**OBJECTION**

State Significant Development Application No: SSD-10300

Coffs Harbour Cultural and Civic Space

PRELIMINARY SCHEMATIC DESIGN
DRAWING

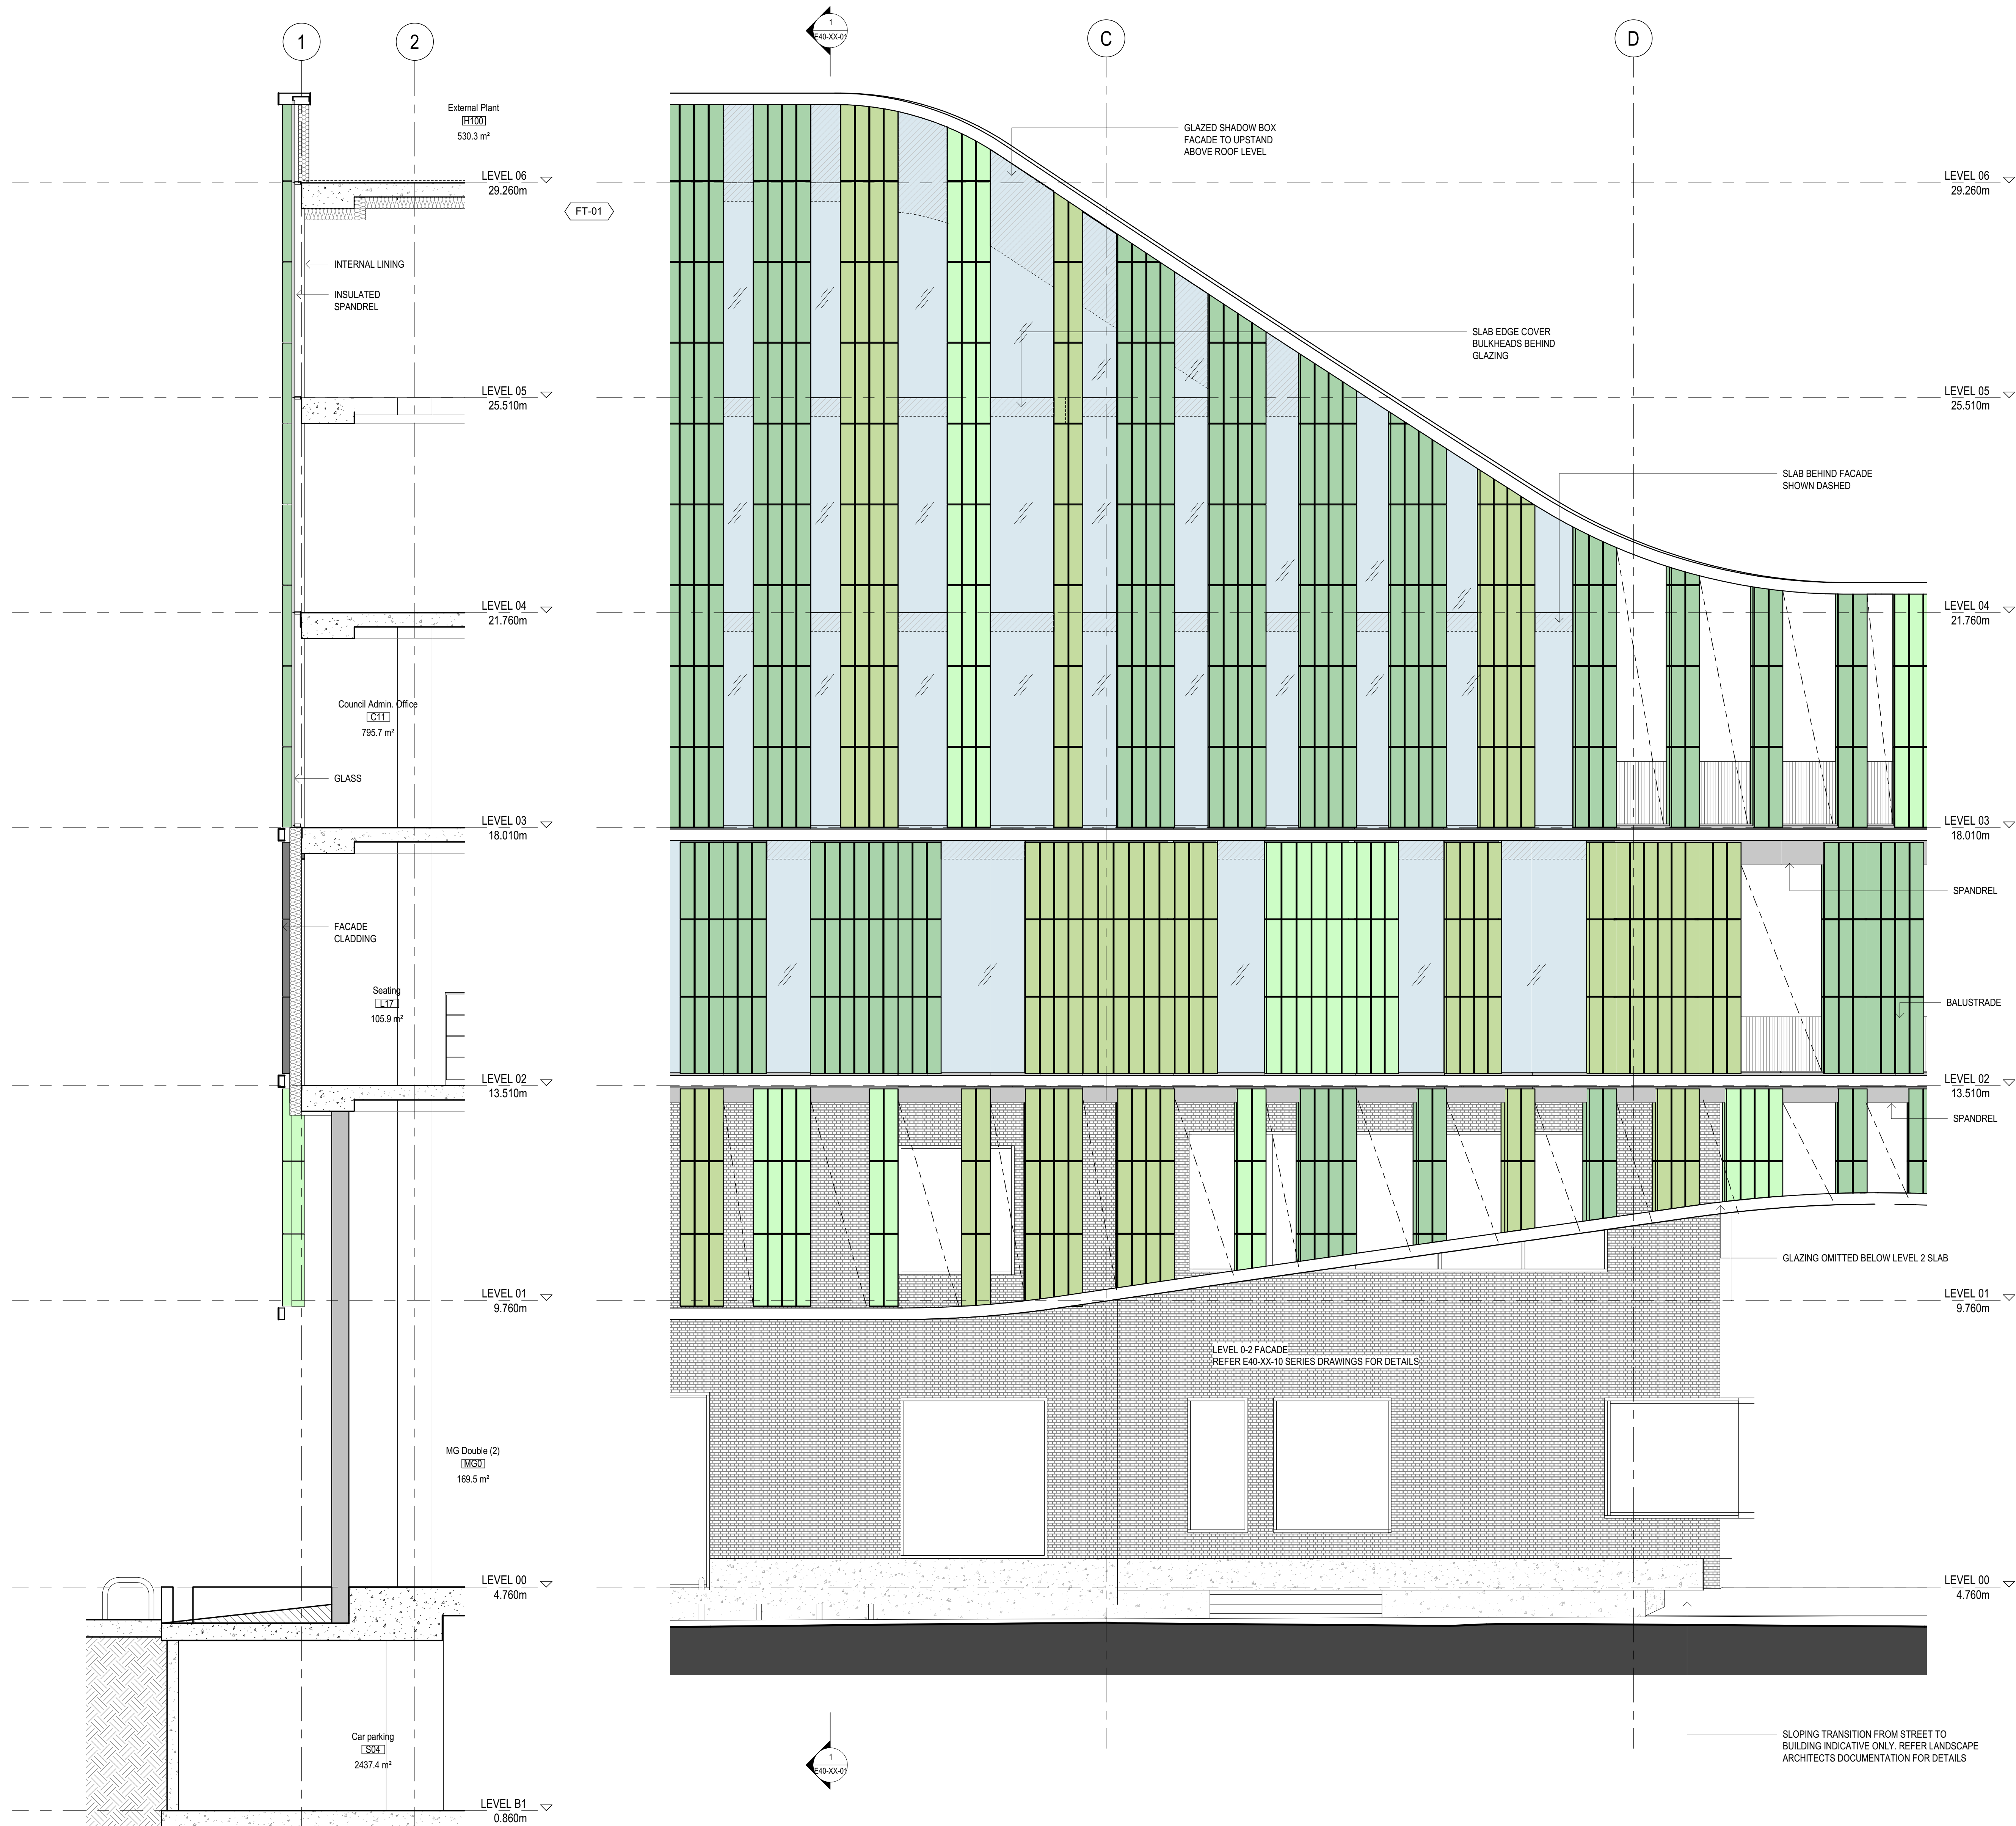
7. As a public building it fails to provide sufficient climate protection for pedestrians during storms and summer sun.
8. The building exceeds the height restriction of 28m set down in Council's own planning controls. Council's argument for variation is not satisfactorily justified and is not consistent with the objectives of the Environmental Planning and Assessment Act 1979, which requires the "the orderly and economic use and development of land". Council should not receive preferential treatment.
